PATCHING PARISH COUNCIL

Application PA/25/08 The Wood Yard France Lane Patching

I write on behalf of the Patching Parish Council to **object** to the above planning application. This site has a long and unfortunate history of which planning committee should be aware. It has been part of the Patching Woodyard for many years, but the Applicant's former husband moved a caravan onto the site. Arun DC obtained an eviction order against him, and he moved. The order, however, did not encompass the Applicant. Despite there being no planning permission in place for the site the Applicant has continued to use the site for her caravan, and other buildings/caravans. She has also constructed an unauthorised access to the highway.

Gates and Crossover

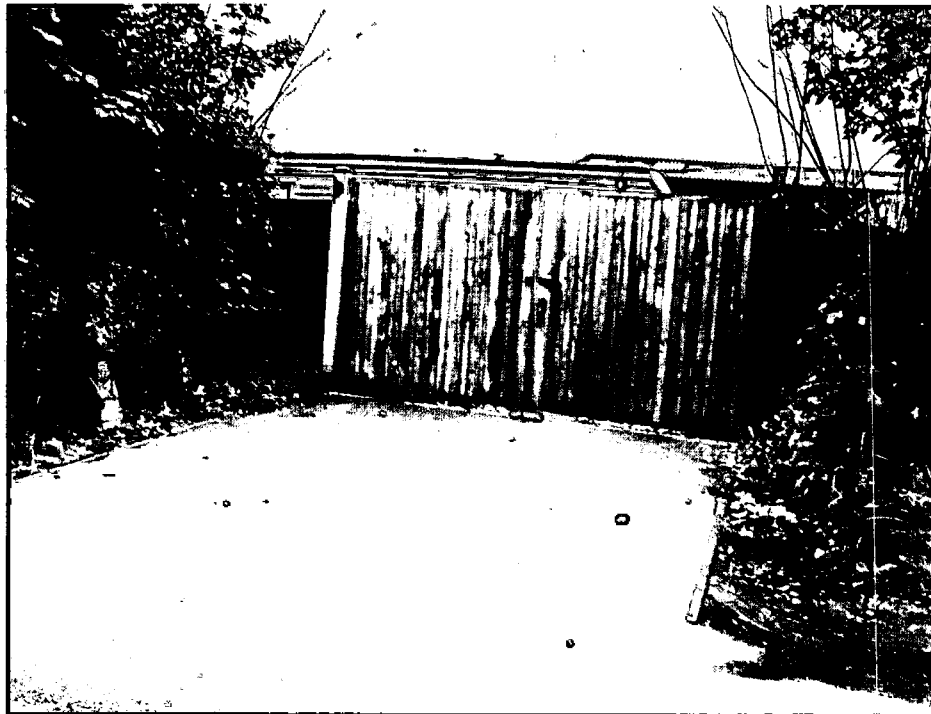
15. The comment from the Highway Authority, includes the requirement that "the gates must open inwards of the property and be set back a minimum of five metres from the highway." This is impossible at this location. The gates can only be set back three metres, and there is insufficient room for the gates to fully open inwards.

16. The above requirement is in order to ensure that "vehicles can be driven off the highway before the gates are opened in the interests of road safety." This will not be possible at this location, and the Council must therefore refuse the application.

17. The access to this site from France Lane poses problems for other road users. The road is narrow here, and barely allows two vehicles to cross. The presence of a vehicle in front of the new gates makes it impossible for two other vehicles to pass on the road. The attached photograph shows that the vehicle could not park without jutting out into the street, even when parked at an angle.
